**From:** Planning  
**Sent:** 02 September 2021 14:57  
**To:** Planning Consultations  
**Subject:** FW: \*RESPONSE\* - Planning Application 21/02839/PLF Objection (RESPONSE NOT SHOWING )

**From:** Sue Green [REDACTED]  
**Sent:** 01 September 2021 13:22  
**To:** Planning <planning@eastriding.gov.uk>  
**Cc:** [REDACTED]  
**Subject:** Planning Application 21/02839/PLF Objection  
**Importance:** High

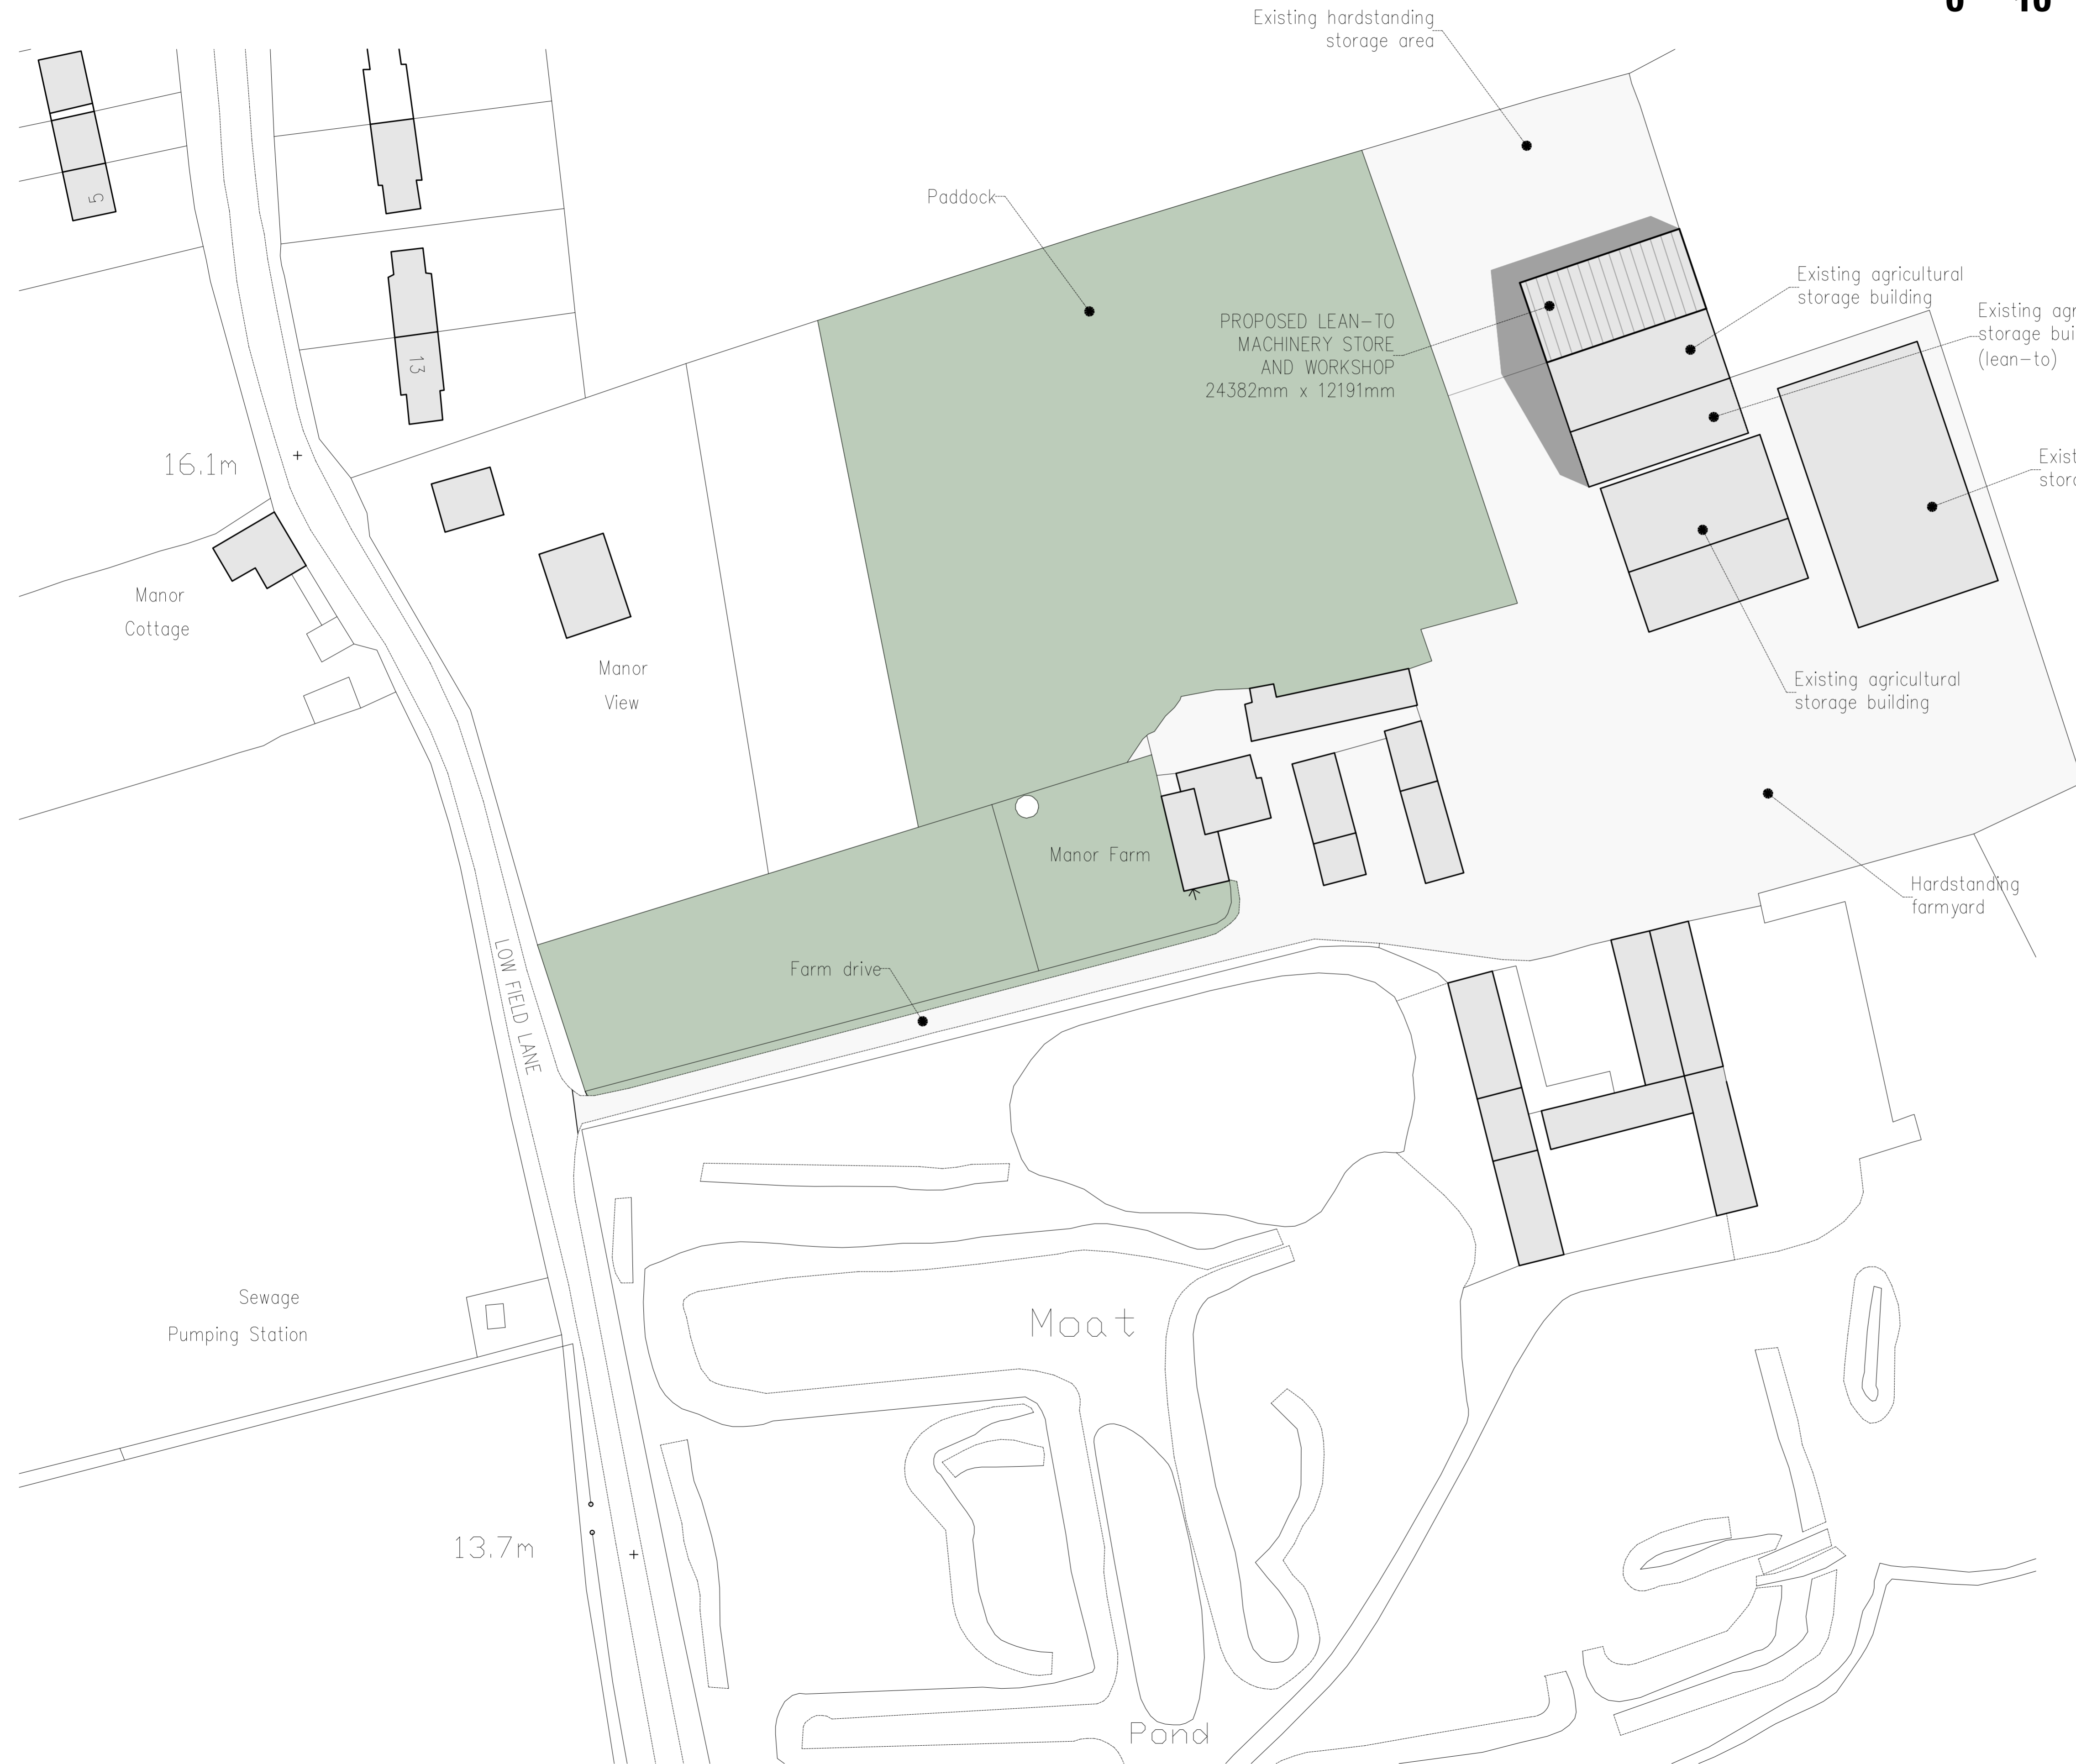
**Layout** The area identified for the new unit on site plan ( drawing No IP/MW/02) has been the site & main storage for the 1,800+ large crates. These images can be seen on various aerial photo sites, <https://eservices.l&registry.gov.uk/eservices/FindAProperty/view/MapEnquiryInit.do> & show the true history of the use of this land rather than the pre-application view created in recently moving these boxes adjacent to our home. The noise involved in moving these boxes throughout the year has been horrific & had a huge impact on our enjoyment, use of our home & mental wellbeing. If the building of this new unit means these boxes will be a

permanent feature at the side of our home, then planning permission must be refused as it will be in breach of our human rights. The location of these boxes must form part of the of this application as relates to the use of the site. We have already complained regarding the noise & use of the land at the side of our home & are currently taking further action on this. A defence of 'best practicable means' would be inadmissible should this further unit be built on land which then renders the only available storage & operational land meters away from my home. Therefore under 'Layout' the application should be refused.
